April 19, 2021
El Paso County Development Services
Attn: Gabe Sevigny
2880 International Circle, Ste 110
Colorado Springs, CO 80910

**SUBJECT: Warner 4-Lot Subdivision
4-Lot Subdivision
Drainage Memo**

DRAINAGE BASIN PLAN  
SCALE: 1"=20'

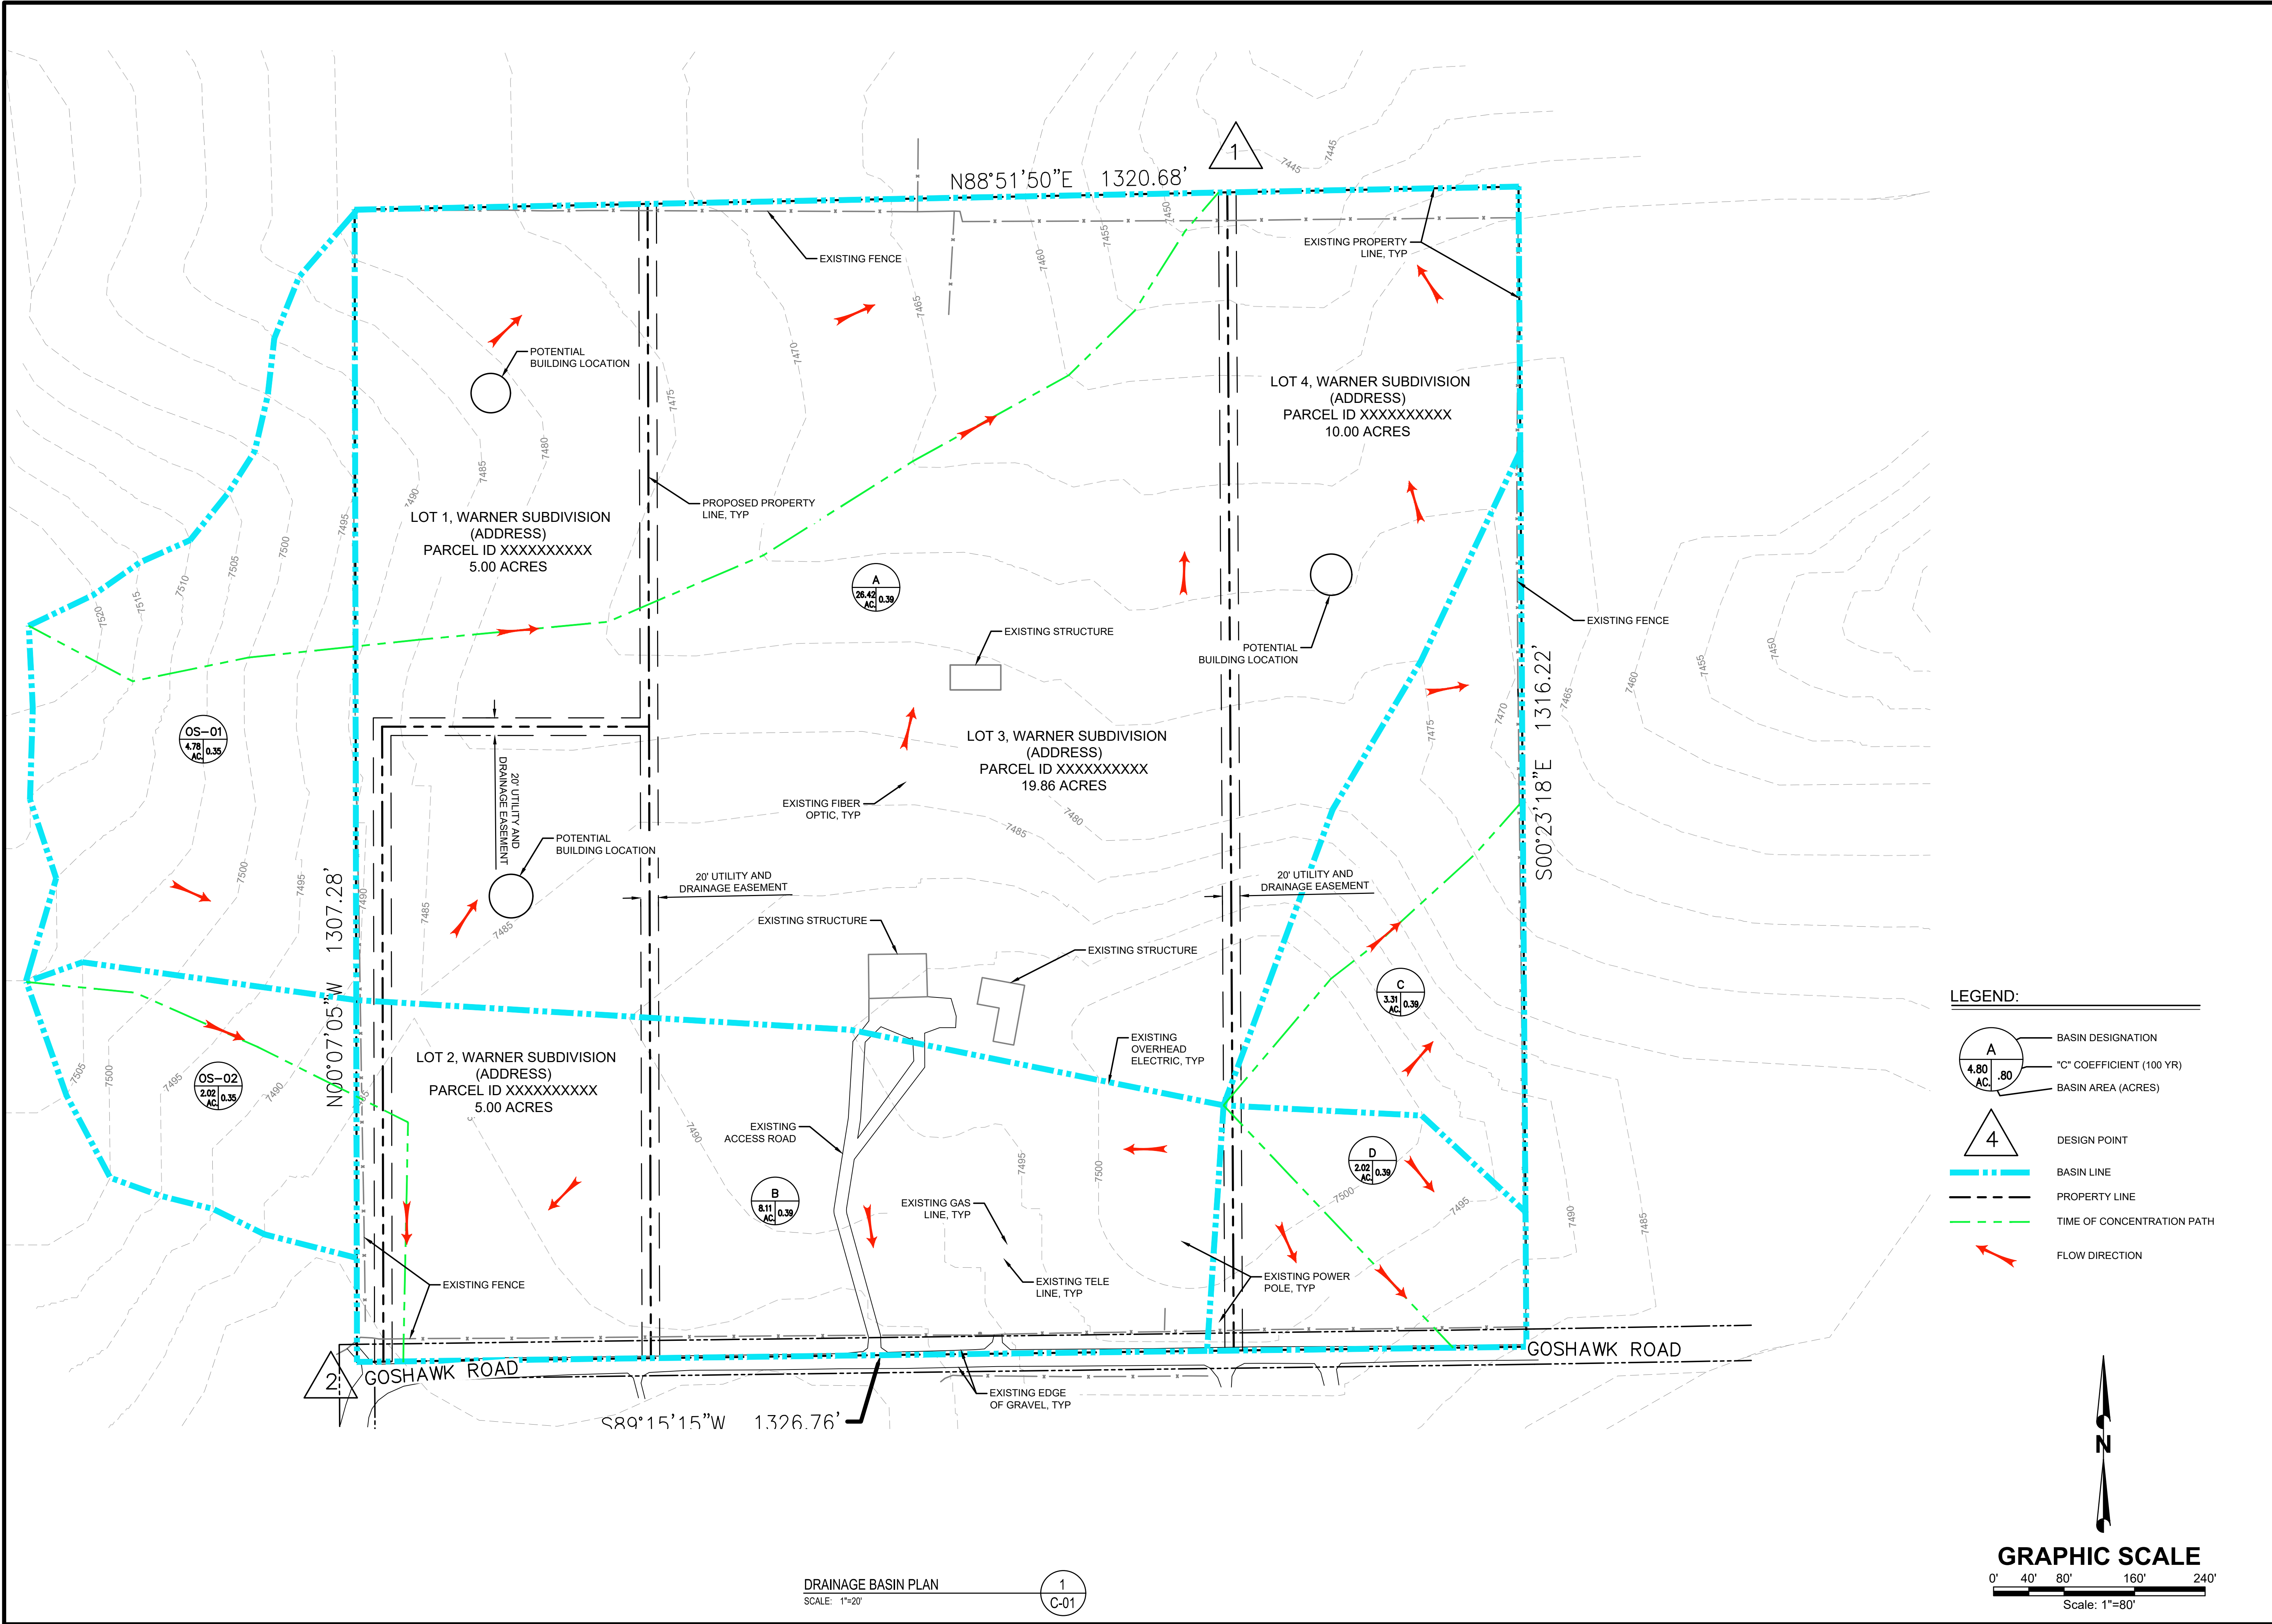
Please clarify where these storm inlets are located. It appears Goshawk Road is a gravel road, which typically does not have inlets. Make sure to show inlets on proposed conditions drainage map if they are within the vicinity of the property.
